Office of Environment & Heritage

DOC18/509985
SSD-9452

Secretary's Environmental Assessment Requirements – Alterations and additions to Australian Museum - 1 William Street, Sydney - SSD-9452

WILLIAM STREET ELEVATION - PROPOSED
AM ADDITIONS & ALTERATIONS

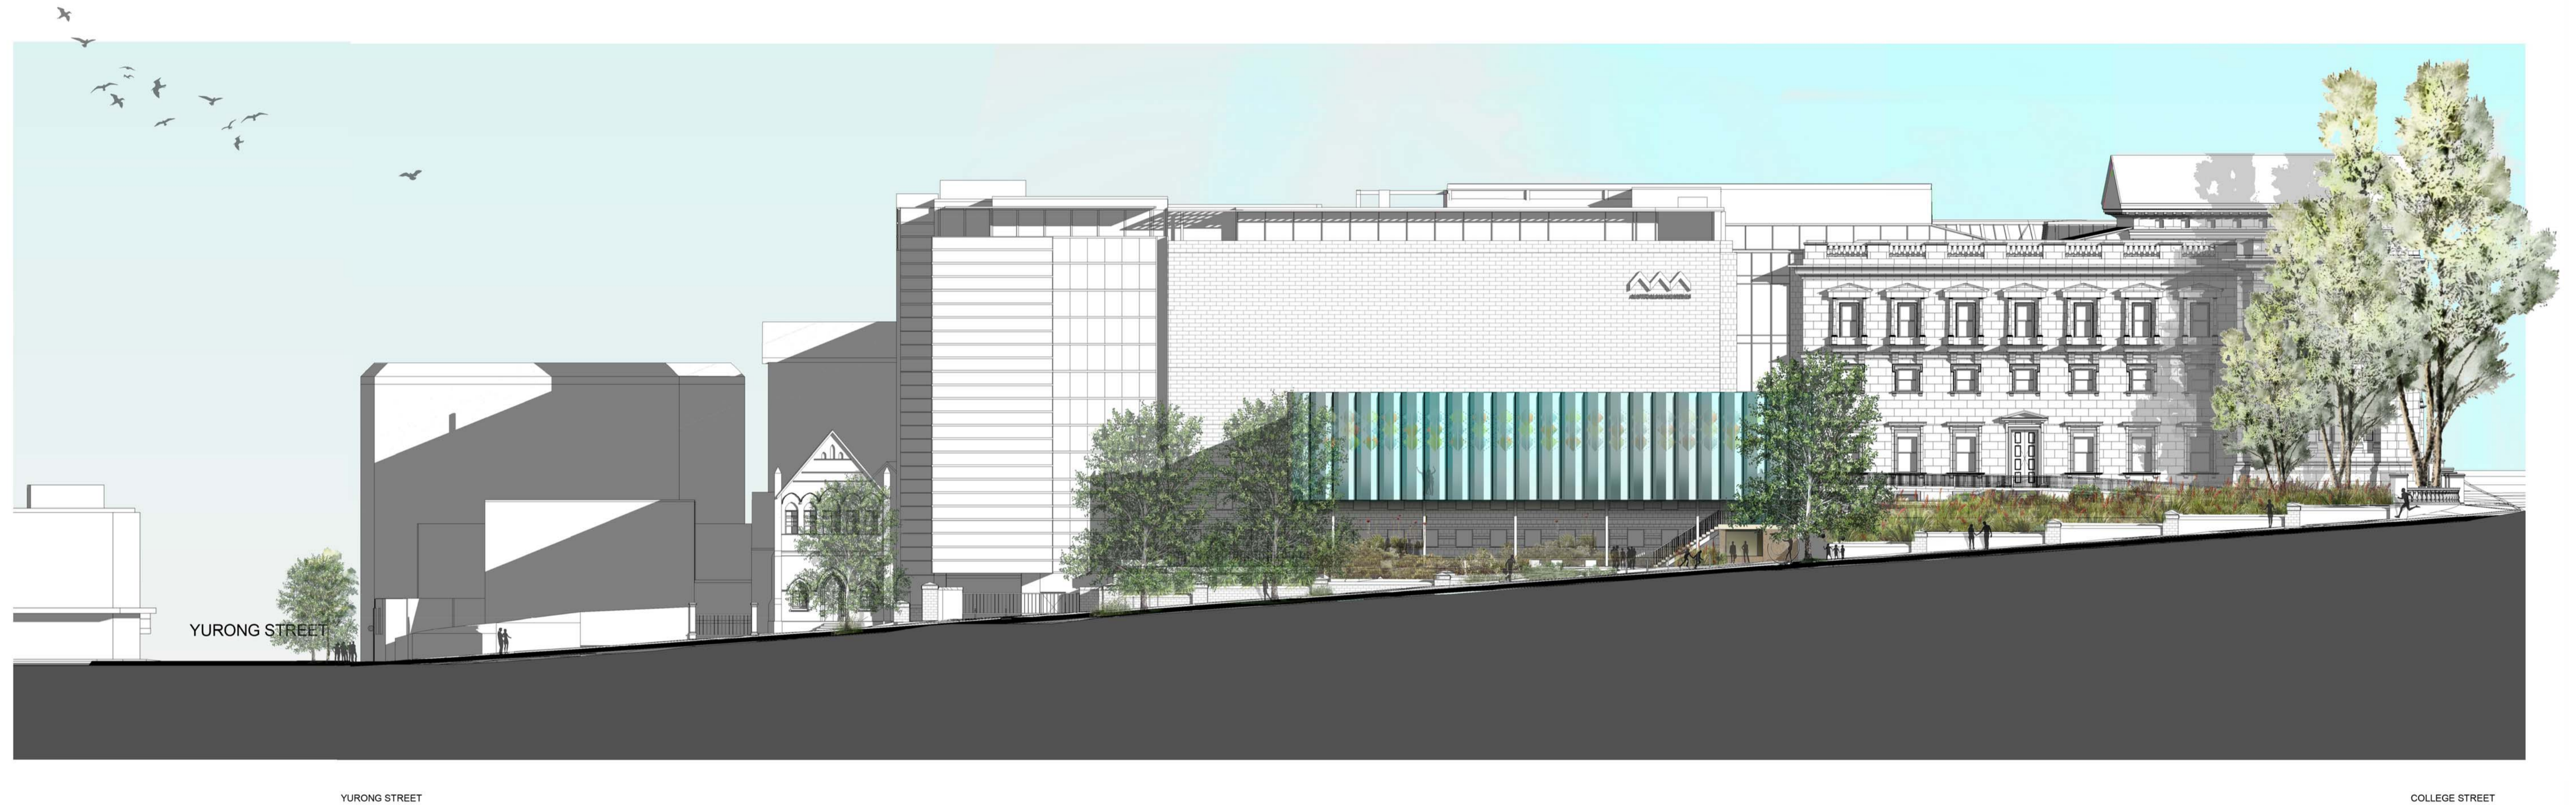
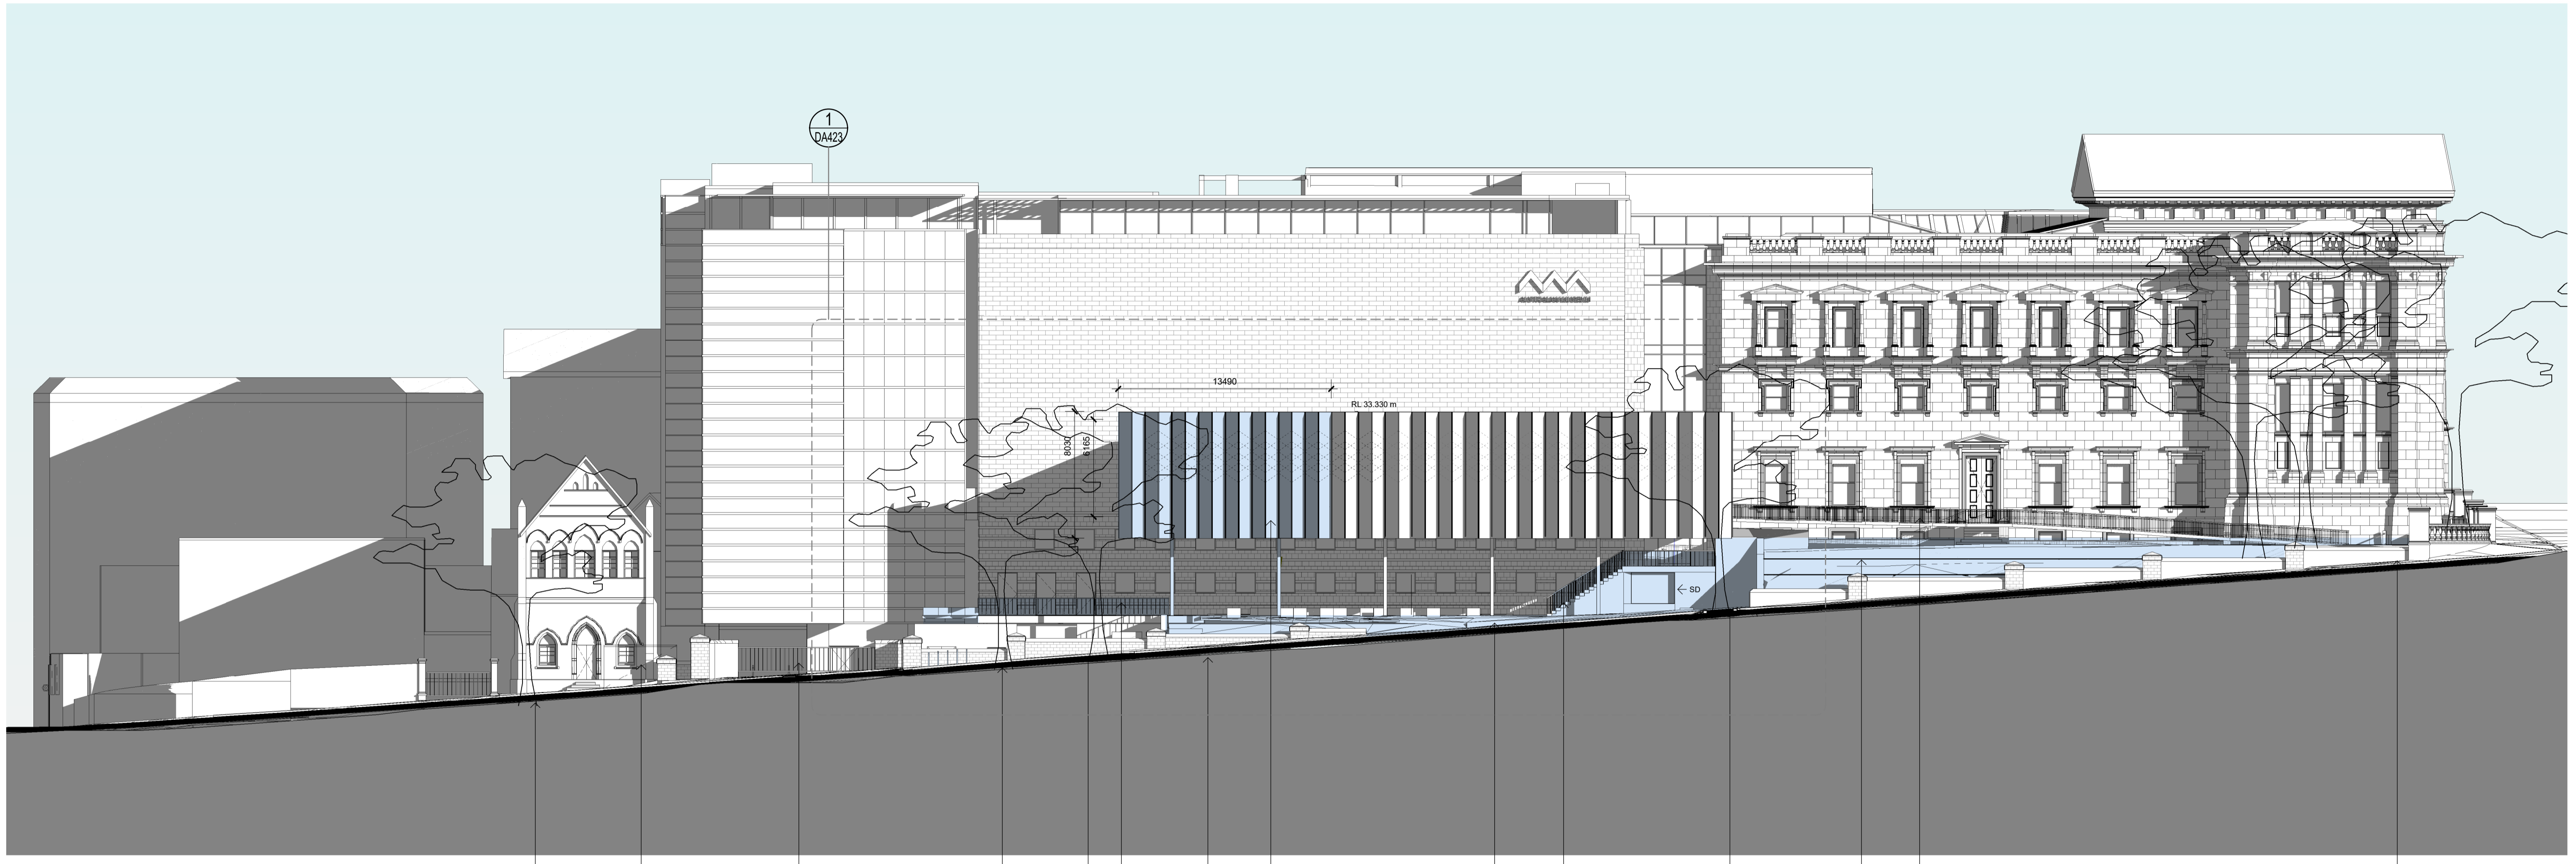
OEH notes the drawings for the Masterplan for Phase 1 - William Street elevation and the Cutaway Perspective show it is proposed to retain the existing tall gum trees near the base of the ramp and new landscaping is proposed to the existing embankment and below Crystal Hall. OEH supports the retention of the existing gum trees - It is recommended the new landscaping for the Australian Museum uses a diversity of local native provenance species (rather than exotic species) and the draft SEARs are amended to include the following:

Landscape Plan:

- *identifies any native trees or shrubs to be removed, retained or transplanted*
- *includes details on the native vegetation community (or communities) that occurs, or once occurred, on the site, with a list of local provenance species (trees, shrubs and groundcovers) to be used for landscaping*
- *specifies that any landscaping will use a diversity of local provenance species (trees, shrubs and groundcovers) from the native vegetation community (or communities) that occurs, or once occurred, on the site, to improve biodiversity.*
